Ribble Valley Borough Council  
Council Offices  
Church Walk,  
Clitheroe  
Lancashire  
BB7 2RA

Phone: 0300 123 6780  
Email: [developeras@lancashire.gov.uk](mailto:developeras@lancashire.gov.uk)  
Your ref: 3/2024/0934  
Our ref: 3/2024/0934/HDC/KW  
Date: 05 March 2026

**Location:** Canine Hydrotherapy Centre Howgill Farm Howgill Lane Rimington  
BB7 4EF  
**Proposal:** Regularisation of unauthorised vehicle access, car park, seating areas  
and siting of tea cabin.  
**Grid Ref:** 382795 446035

Drawing No; P100 - 17/11/25

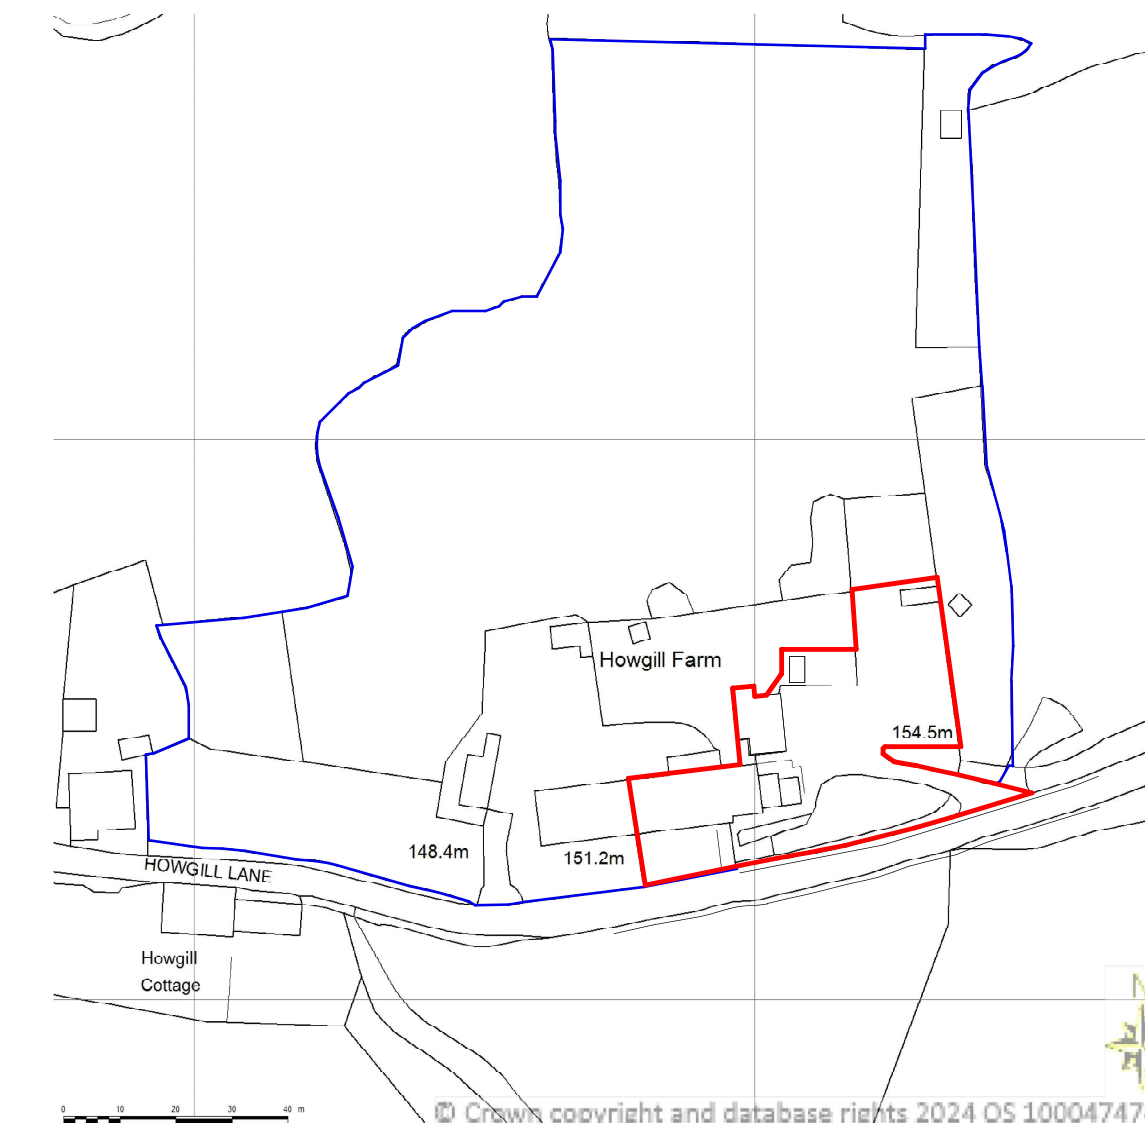
An acceptable visibility splay has also been provided within drawing number P100.2 - 30/01/26. Whilst the provided visibility splay is not in line with the requirements for the speed limit, given the nature of the road, speeds are likely to be slower in proximity to the access.

The visibility splay is wholly within the land which the applicant controls and/or the adopted highway and nothing shall be erected, retained, planted and / or allowed to grow at or above a height of 0.9 metres above the nearside carriageway level which would obstruct the visibility splay of the proposed access.

The proposal also includes car parking provisions, as can be seen within drawing P100.2 - 30/01/26. The plan shows 20 marked out bays as well as an additional hardstanding area. Given the information provided within the operating statement, the LHA is of the view that the parking provisions are acceptable in this case. Should the demand for parking increase the 11 staff members within the site could block each other in, as well as the 9 students who attend training sessions within the site, given that they are likely to arrive and leave the site at the same time. The site also functions strictly on an appointment-only basis; as such, they have control over the demands within the site.

drawing P100.2 - 30/01/26. Nothing shall be erected, retained, planted and / or allowed to grow at or above a height of 0.9 metres above the nearside carriageway level which would obstruct the visibility splay. The visibility splays shall be maintained free of obstruction at all times thereafter for the lifetime of the development.

4. The car parking area shall be surfaced or paved in accordance with a scheme to be approved by the Local Planning Authority and the car parking spaces and manoeuvring areas marked out in accordance with the approved plan, drawing P100.2 - 30/01/26. The car parking area shall thereafter be kept free of obstruction and available for the parking of cars at all times.
